Our ref: HA/2009/108514/01-L01
Your ref: AL/114/09
Date: 04 December 2009

**RE-USE OF REDUNDANT FARM BUILDINGS FOR MIXED USE
DEVELOPMENT - B1 OFFICES, RESIDENTIAL DWELLINGS & TOURIST
ACCOMMODATION UNITS**

NEW HOUSE FARM NORTON LANE ALDINGBOURNE

SITE SECTION EAST WEST - 1:100

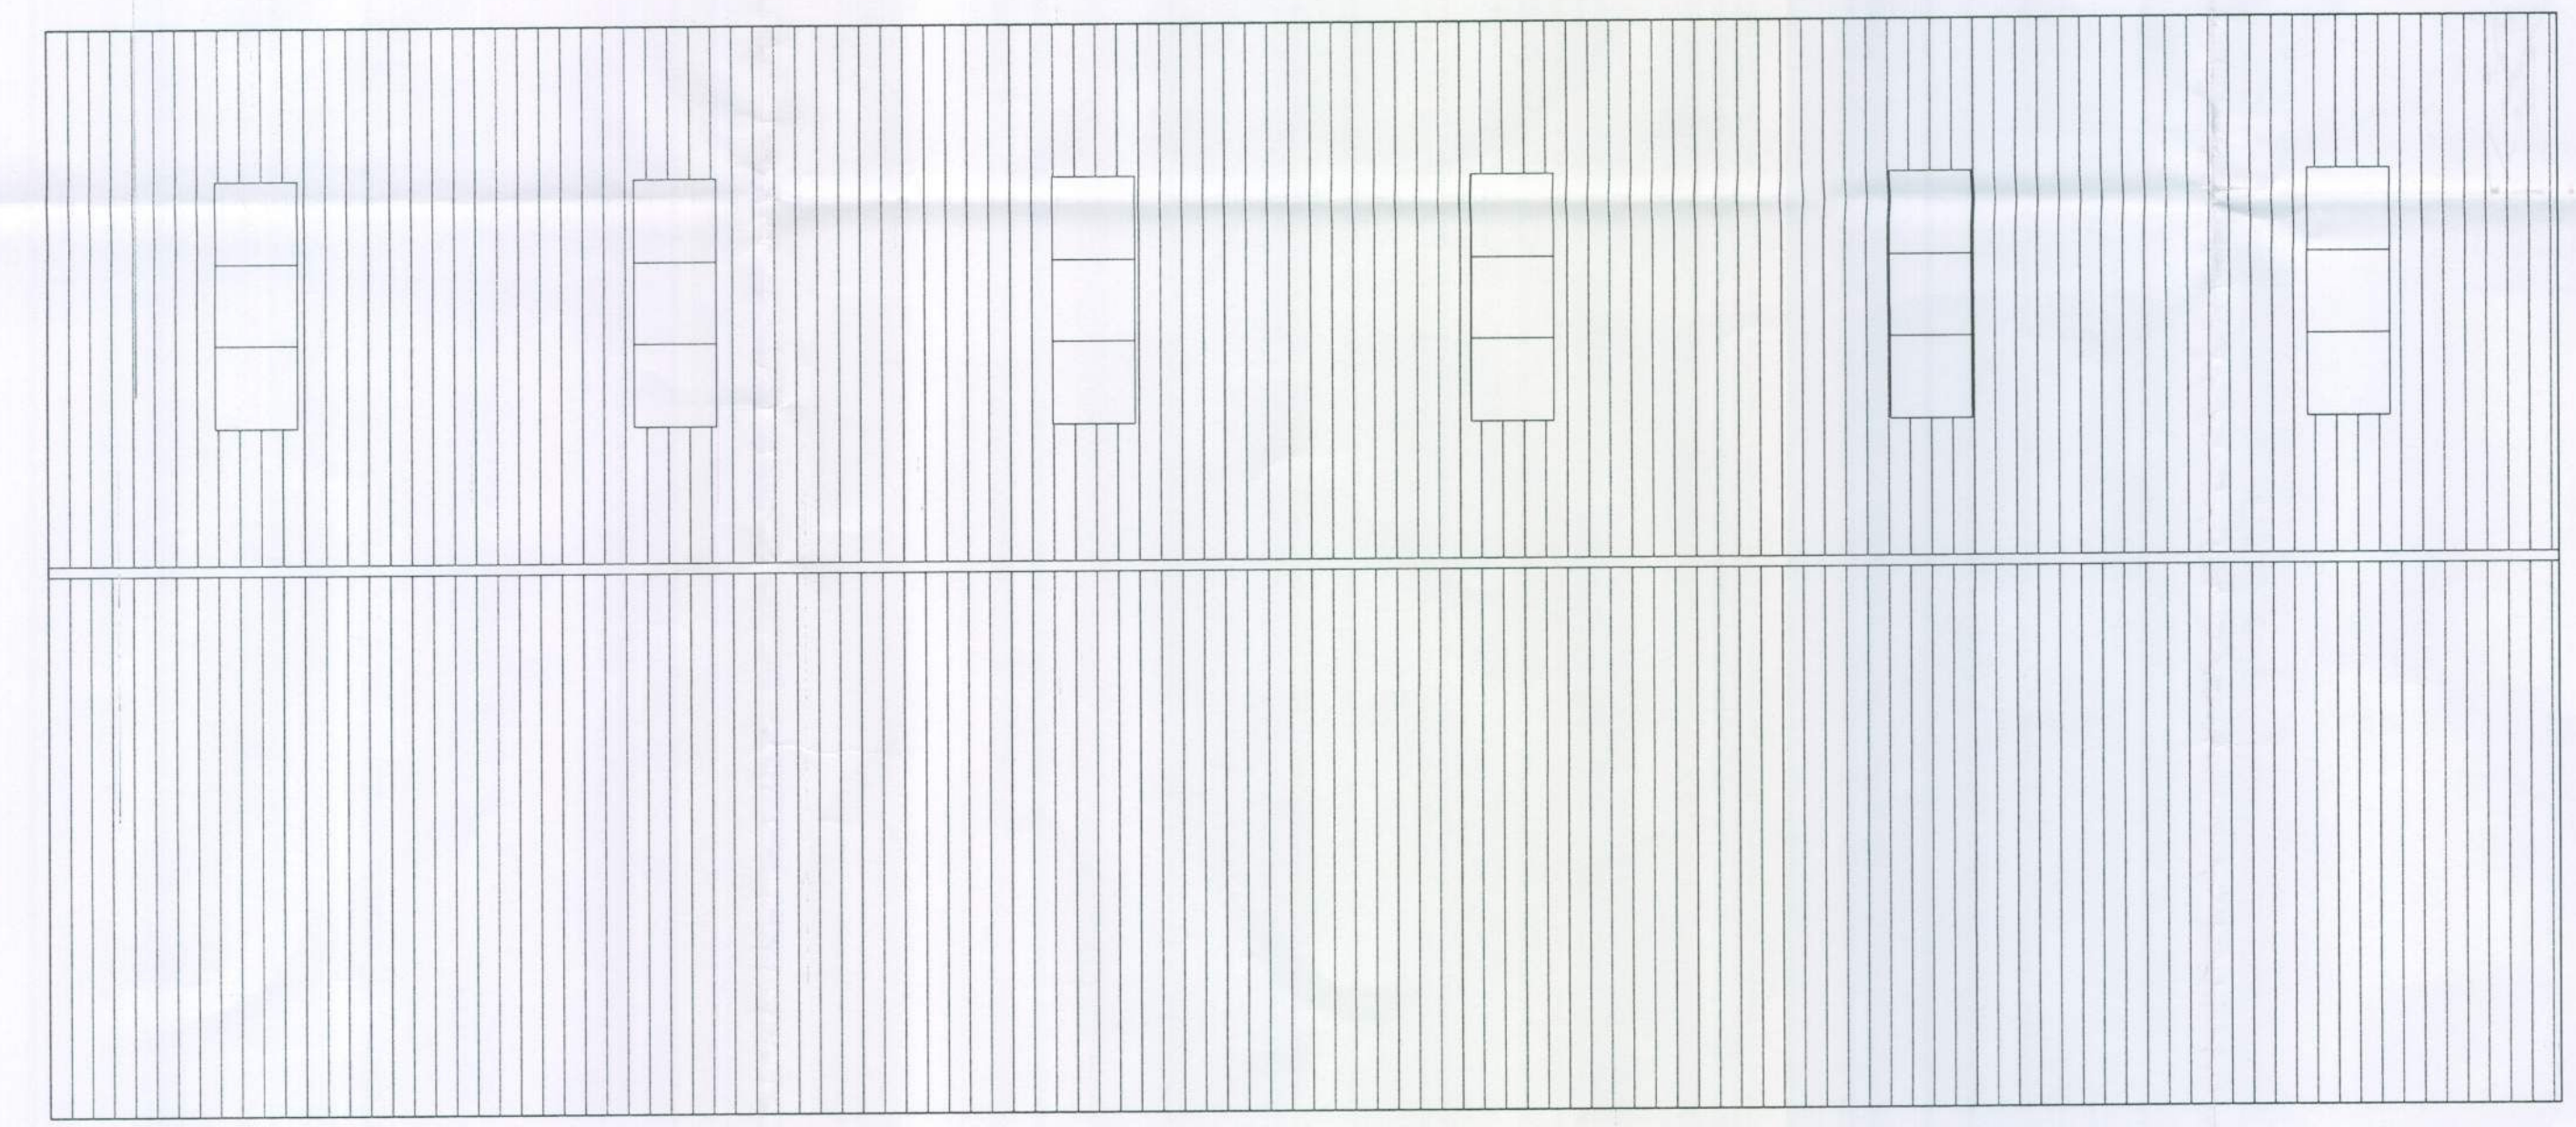
1. Flood-proofing measures detailed in section 19.
2. Finished floor levels are set no lower than 300mm above ground level.
